From: Timothy Batin <batt@yakamafish-nsn.gov>
Sent: Tuesday, March 18, 2025 2:16 PM
To: Ellie Myers
Subject: SP-25-00005 Hanson

Subject: SP-25-00005 Hanson - Notice of Application

TO: All Staff
FROM: Public Works Plan Review Team
DATE: April 1, 2025
SUBJECT: SP-25-00005 Hanson

HANSON ROAD SHORT PLAT
 PART OF SECTION 11, T. 17 N., R. 17 E., W.M.
 KITTITAS COUNTY, WASHINGTON

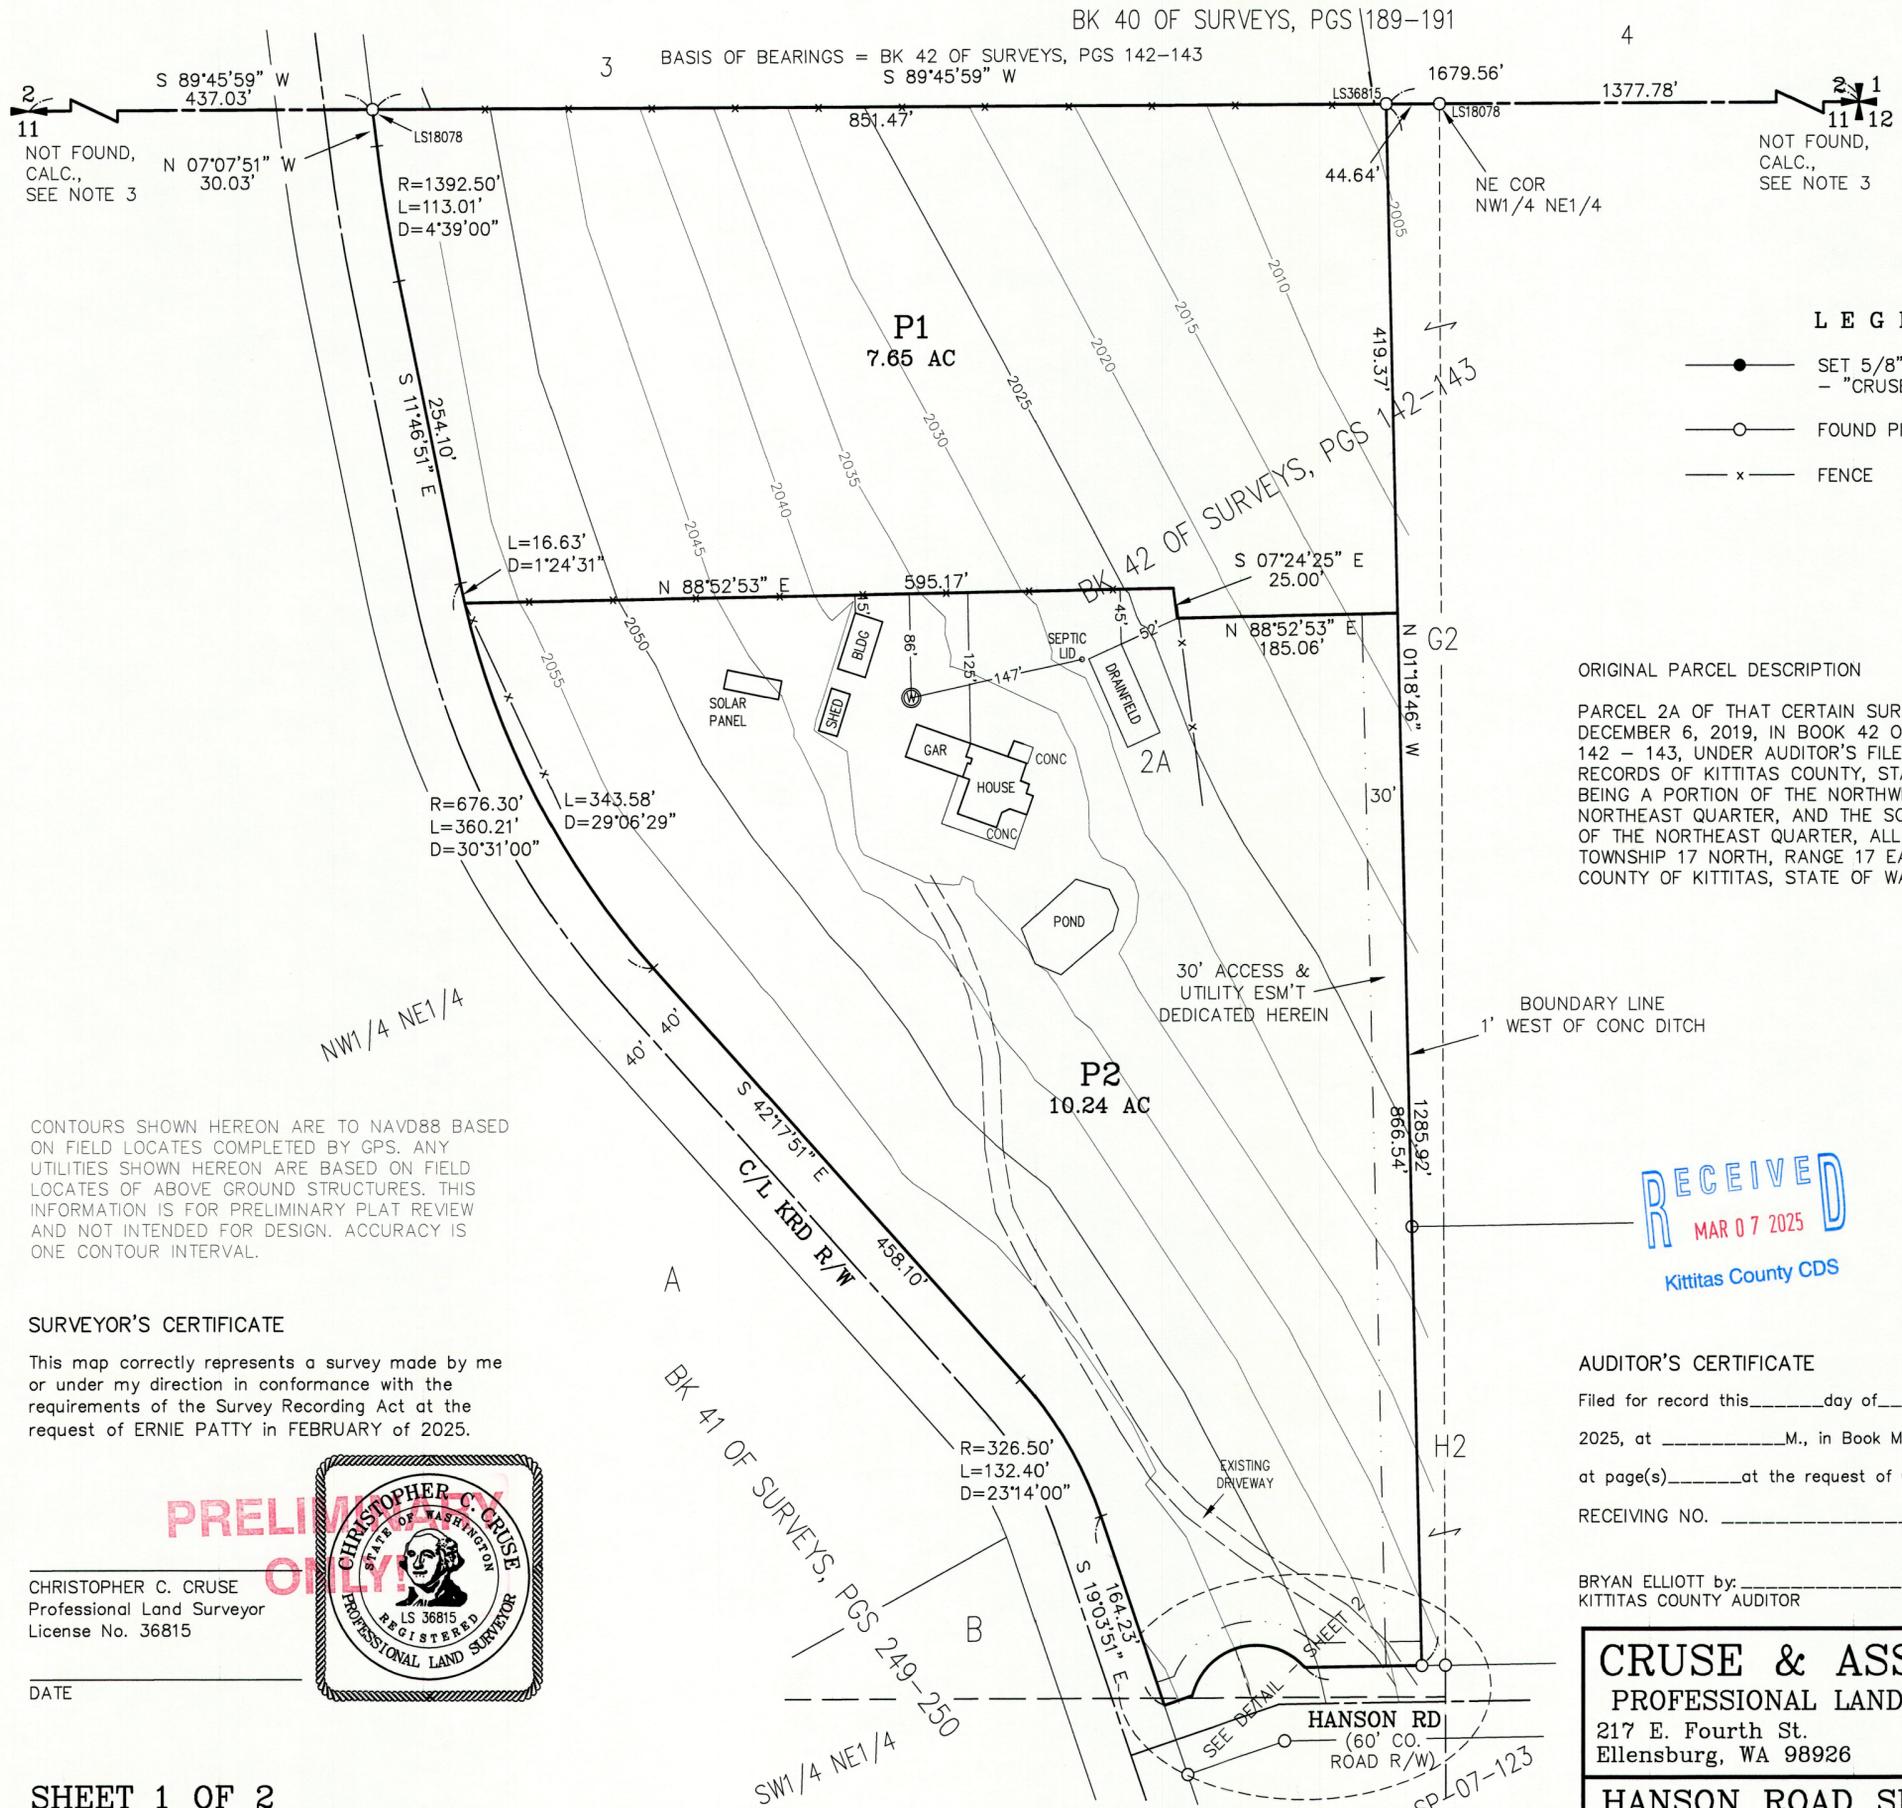
SURVEY	<ol style="list-style-type: none"> 1. The proposed new boundary does not meet the setback requirements of KCC:17.29.080. 2. Of the 8 property corners shown, only 3 can be mathematically retraced from this survey. If any of the others have been utilized for survey control, ties to them shall be shown on the face of the survey. 3. The detail window on sheet 2 appears to have the West line of the access easement drawn in the incorrect position. (JT)
TRANSPORTATION CONCURRENCY	No transportation concurrency requirement for this project. (KAH)
FLOOD	Parcel #960081 is not within a FEMA identified special flood hazard area (100-year floodplain). A floodplain development permit is not required. (SC)
